RE: 64 WESTFIELD LANE, SCHOLDS, CLECKHEATON BD19 6DR

OBJECTION TO DEMOLITION OF EXISTING BUNGALOW AND GARAGE AND ERECTION OF DETACHED DWELLING AND DOUBLE GARAGE.

REF: 2023/91228

FIRST FLOOR PLAN

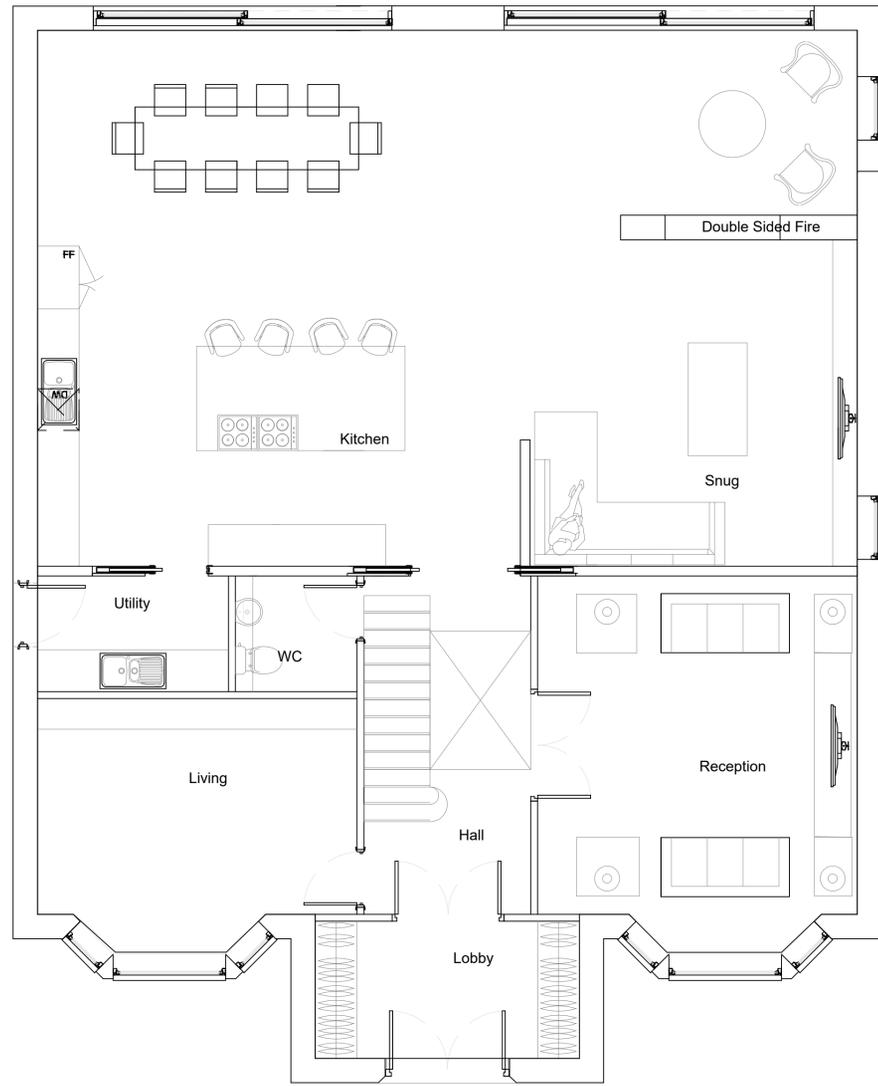
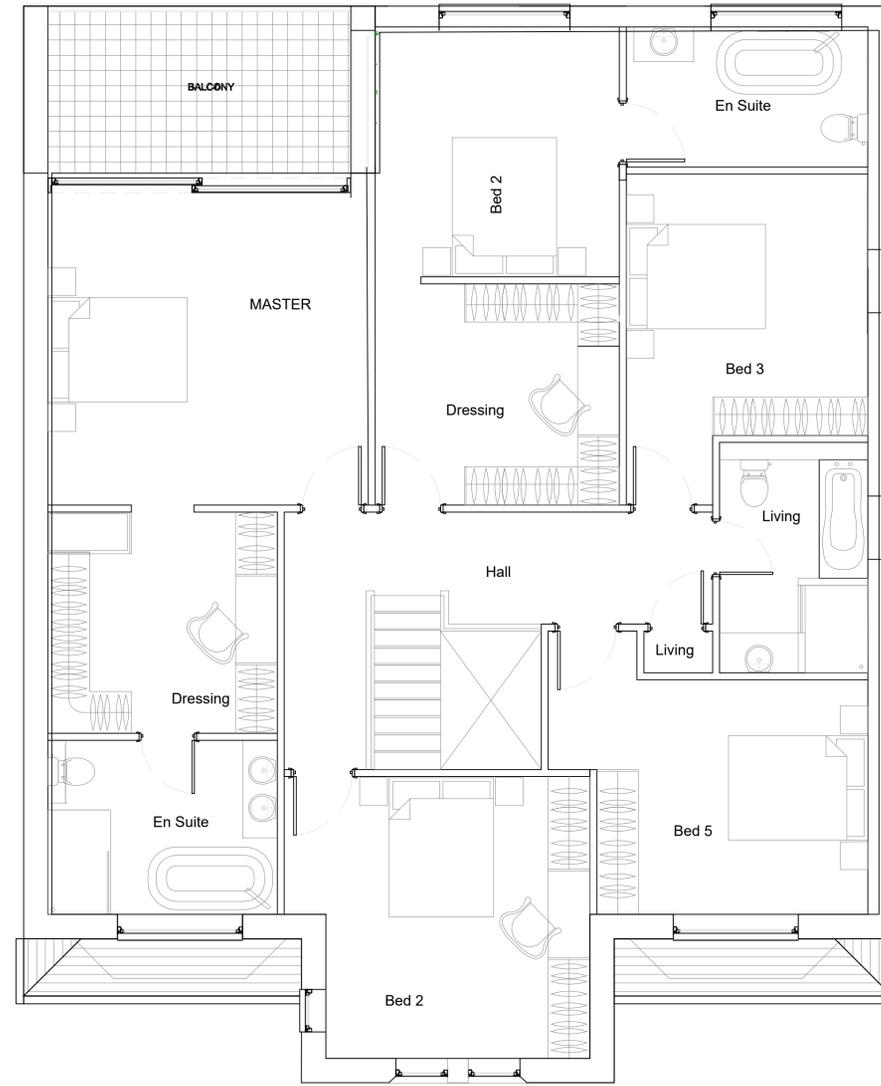
The application shows the proposed property location towards the rear of the site. I know this is in line with the property to the west side, but the property on the east side is closer to the road. To offer more privacy to the neighbouring properties at the north side, a suggestion would be to move the proposed property further forward on the plot. This would create more privacy for the neighbouring properties at the rear as well as to the occupiers of the proposed plot.

NORTH ELEVATION

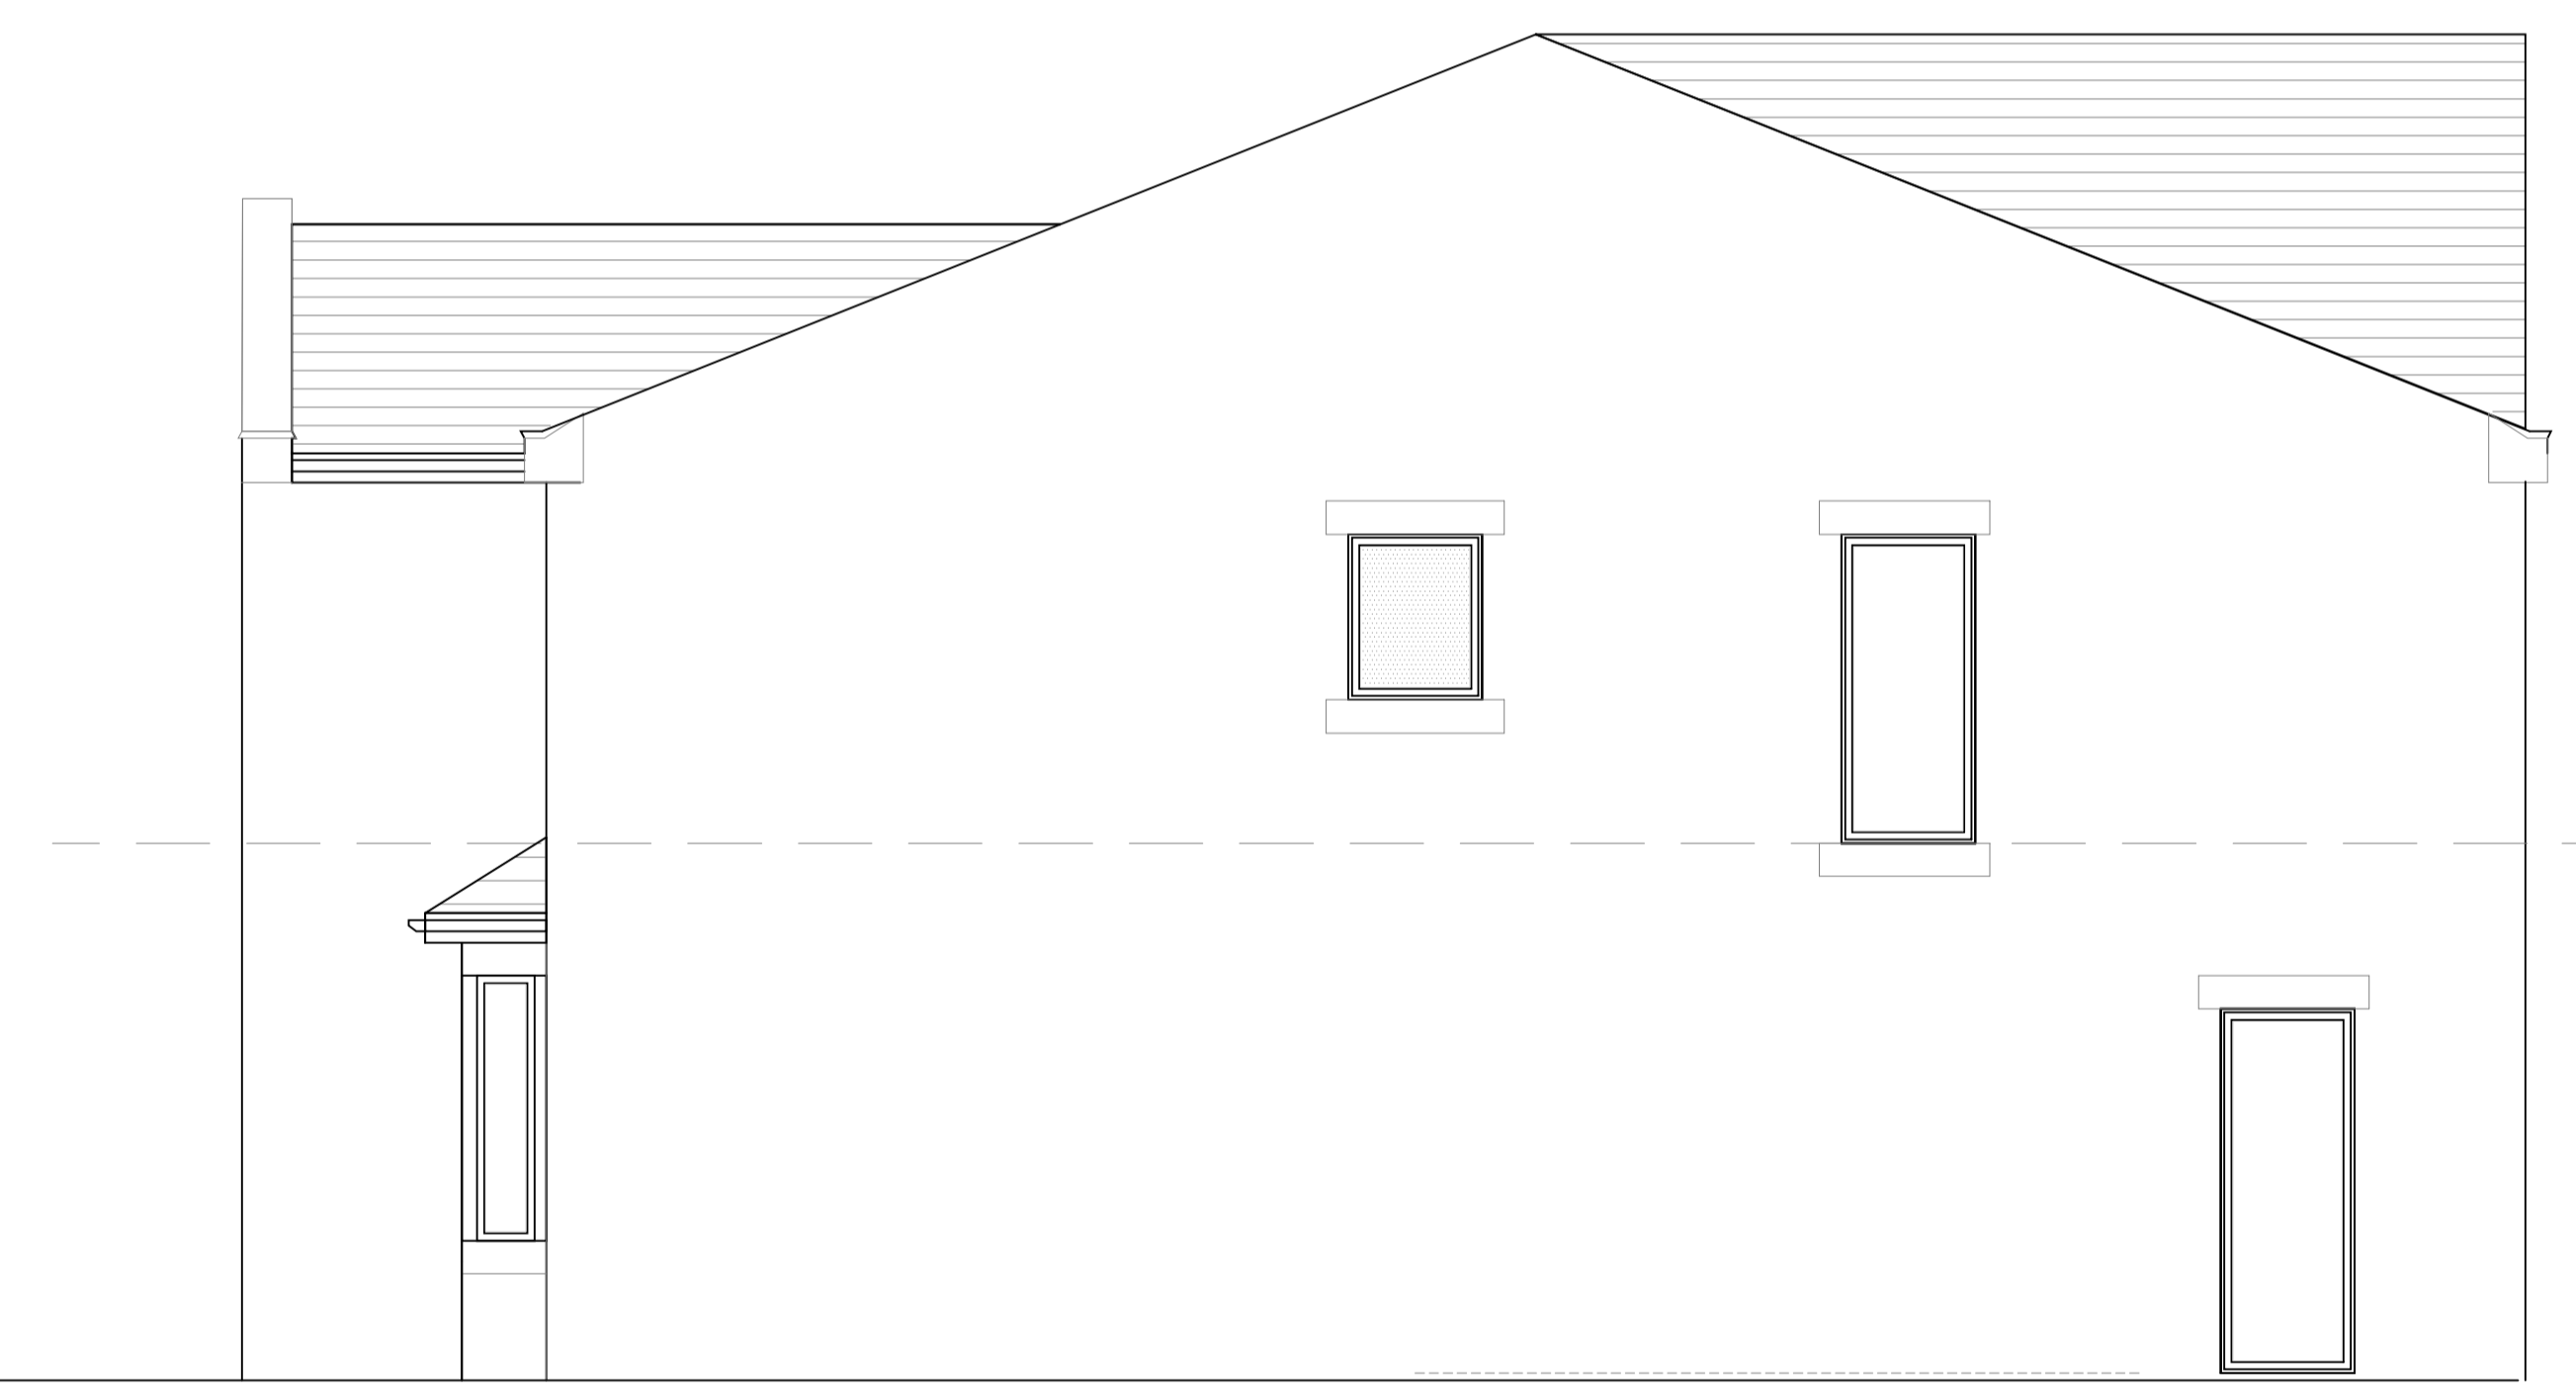
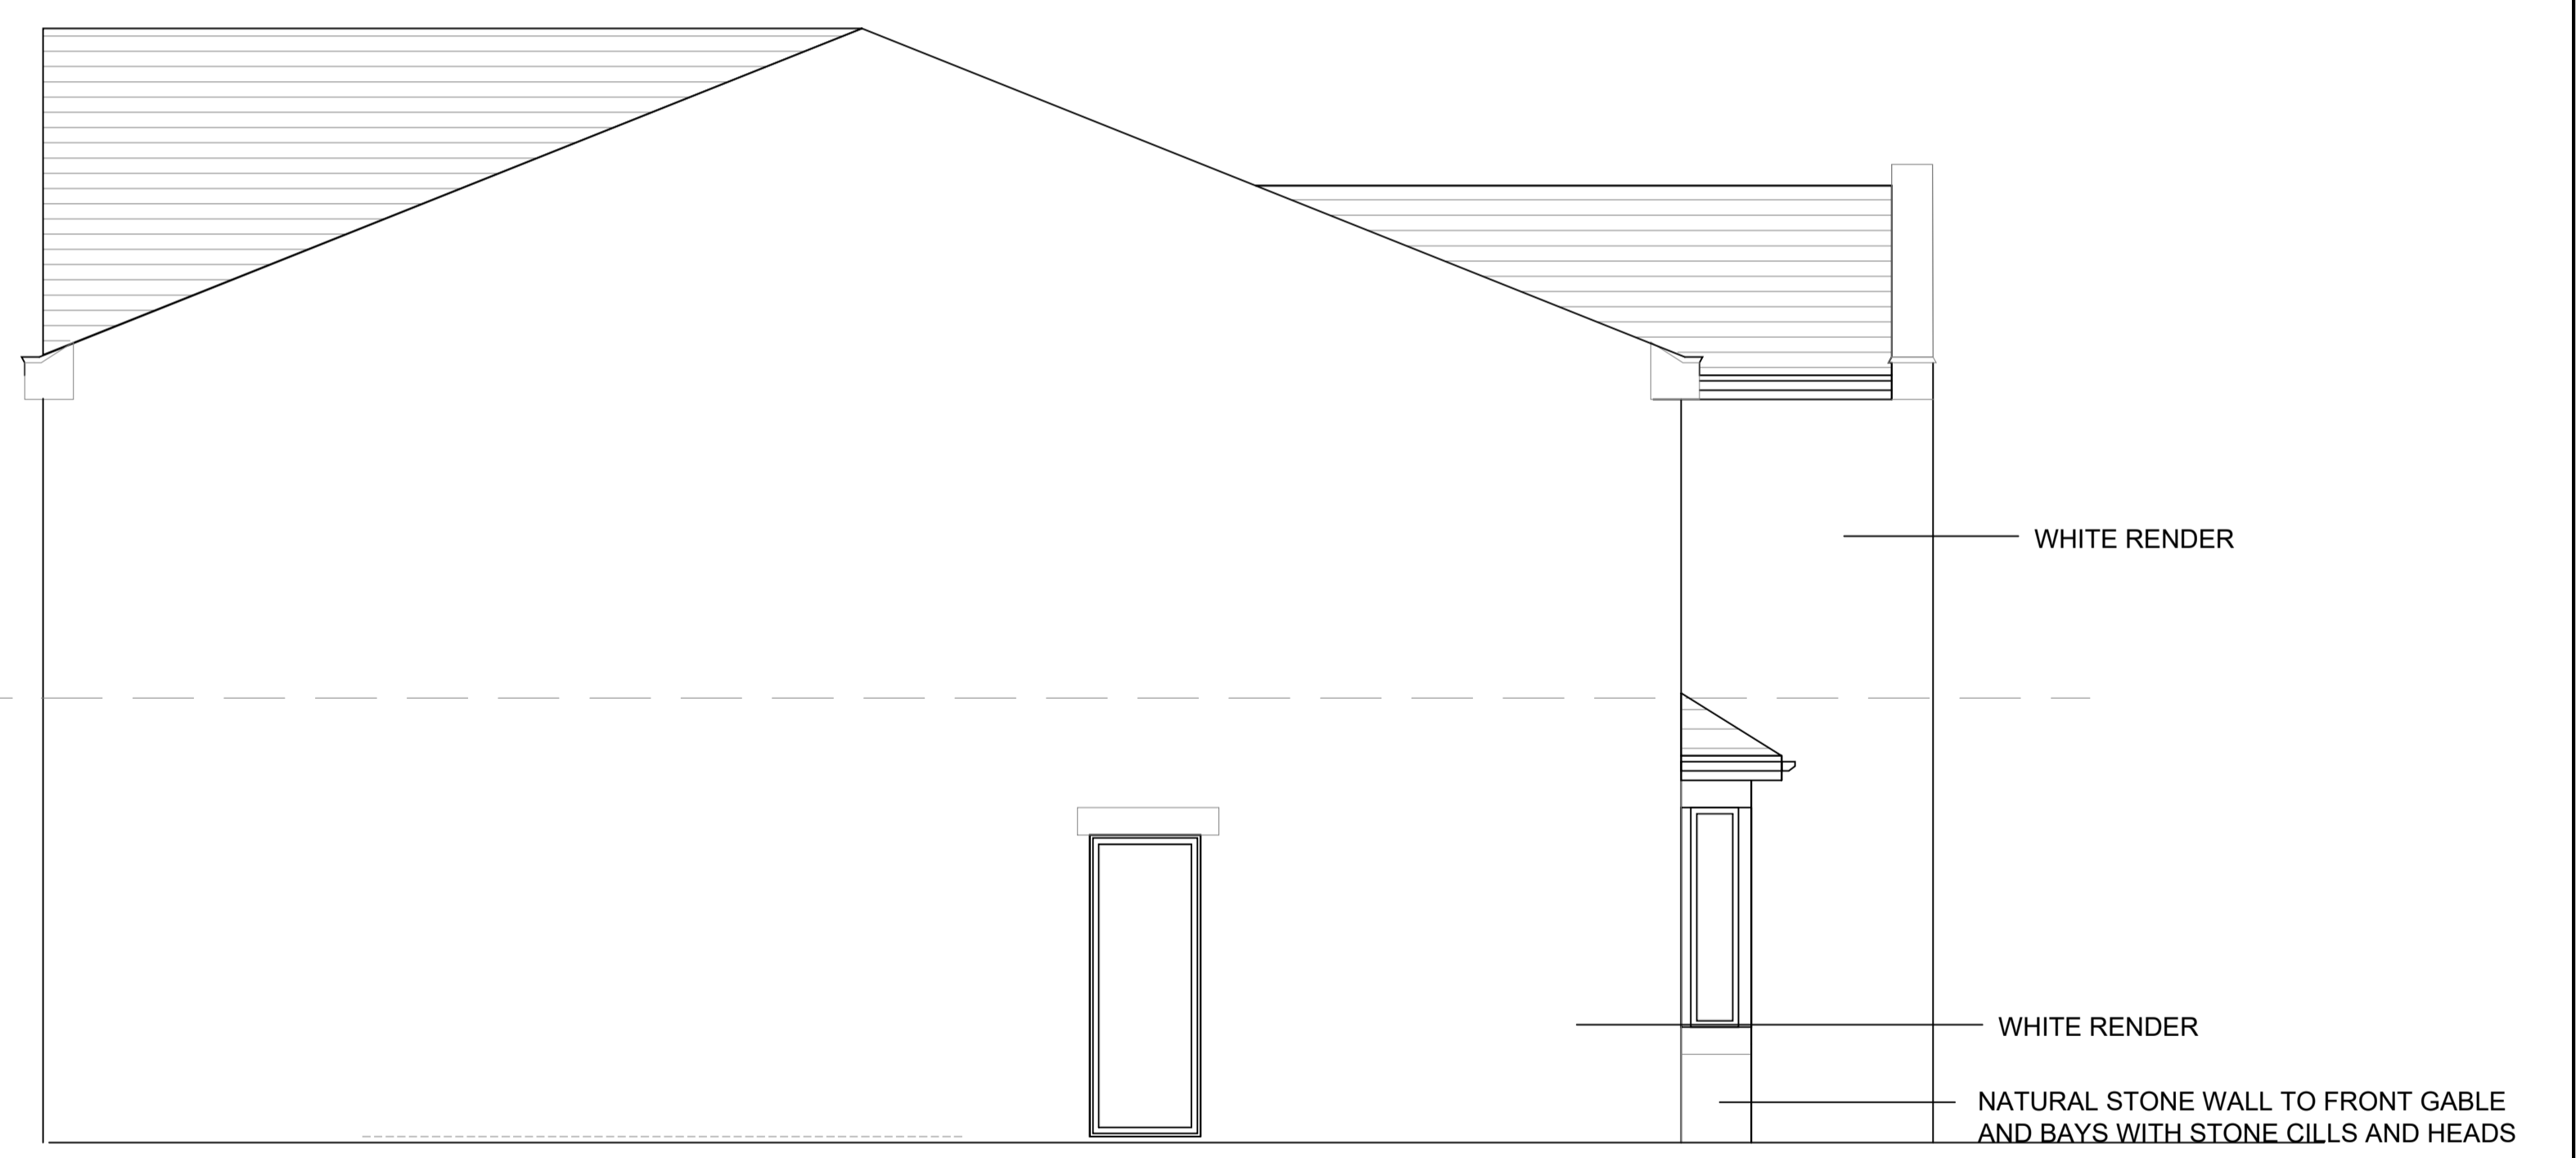
For many years, there has only been a bungalow on this site, so the properties to the rear of the bungalow have always been very private. The proposal to add a 5 bedroomed dwelling on to this site complete with a full size balcony to the rear will certainly mean a lack of privacy for myself as well as the neighbouring properties on Thirlmere Avenue which have never been overlooked before and this will certainly be of detriment to our residential amenity and would surely affect the value of the properties.

In the previous planning permission that you PASSED, please refer to Section 7 and the privacy of the neighbouring properties. You have stated there shouldn't be a loss of privacy to neighbouring properties, yet this application has a full size balcony at the rear of the property which would overlook all the surrounding properties. Please bear in mind your statement in Section 7 when looking at this current proposal.
